**Consultation Response from KC,
Highways Development Management**

2024/92847 Clover Farm, Scout, Woods Mount, Marsden, Huddersfield, HD7 6LD

**Discharge of details reserved by condition 9 (passing places) on previous permission
2023/90469 for demolition of stables/food store and commercial workshop and erection of one
dwelling for holiday let**

Plan Revised A
scale 1:1000 @ A3
reference DBAR/1024/06A

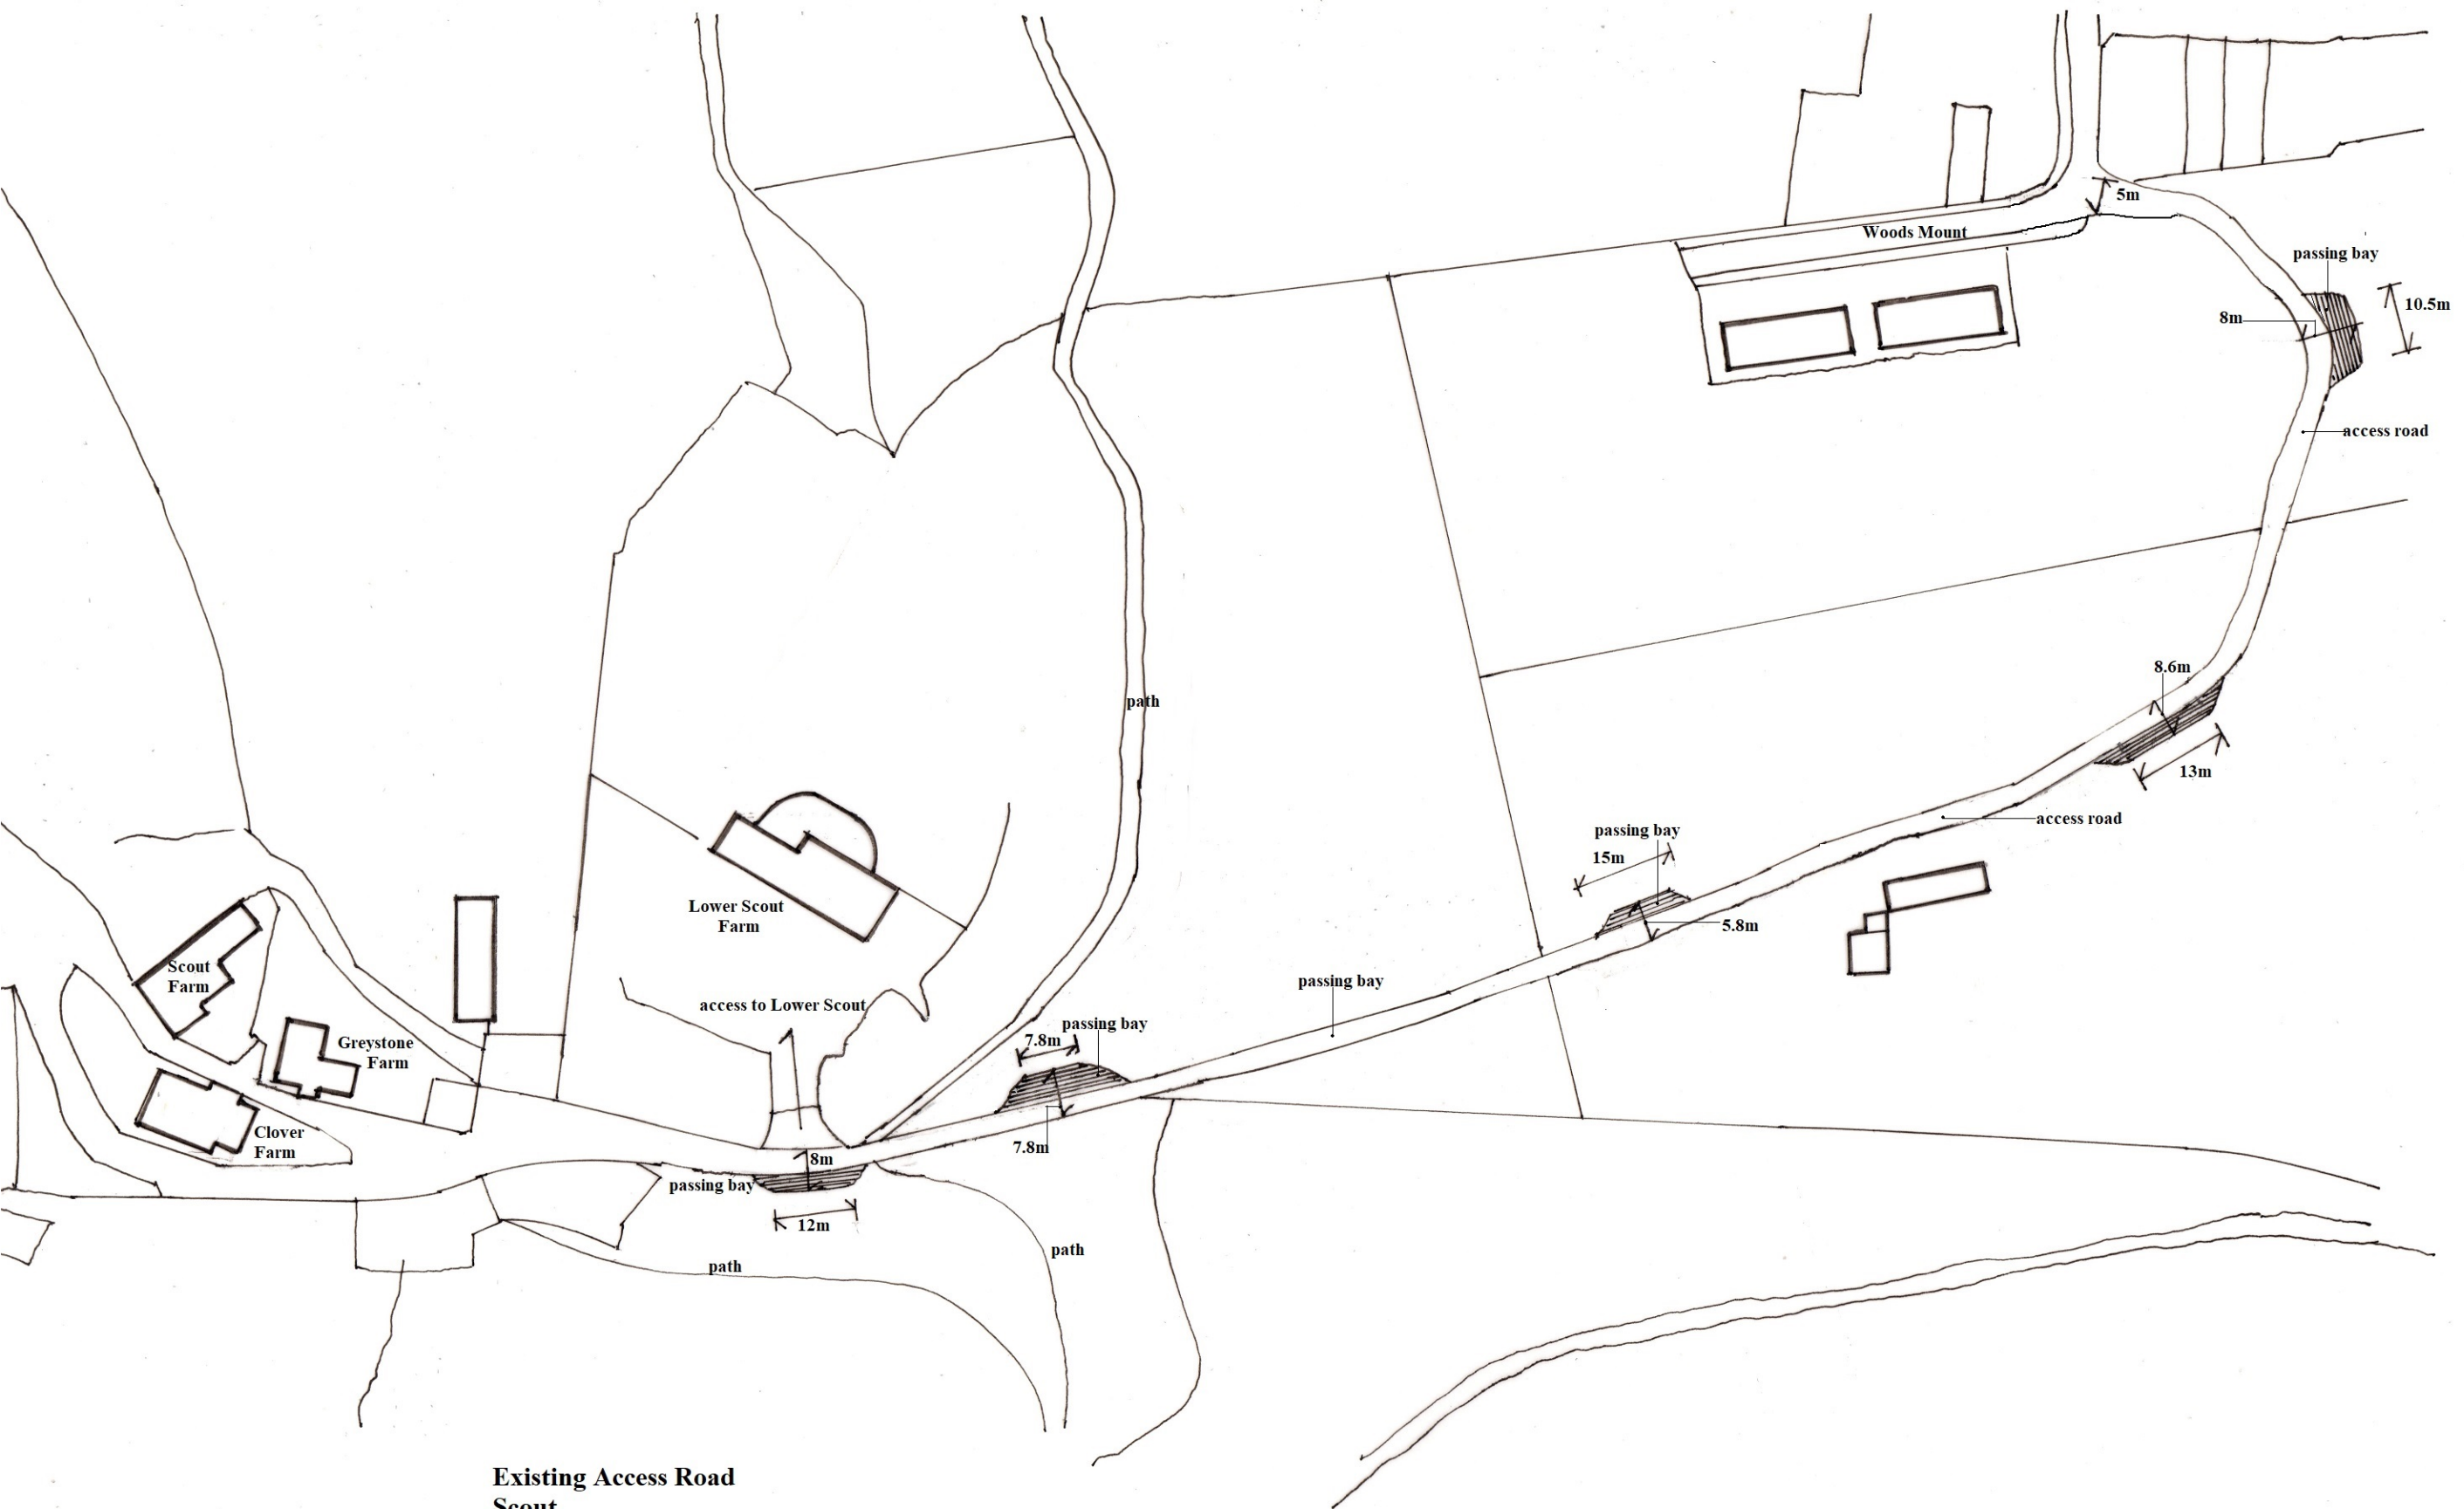
Drawing No DBAR/1024/06A Revision A has provided suitable details of the location and size of the vehicle passing places along the access track leading to the development from Woods Mount.

The drawings as submitted are therefore acceptable and condition 9 can be discharged.
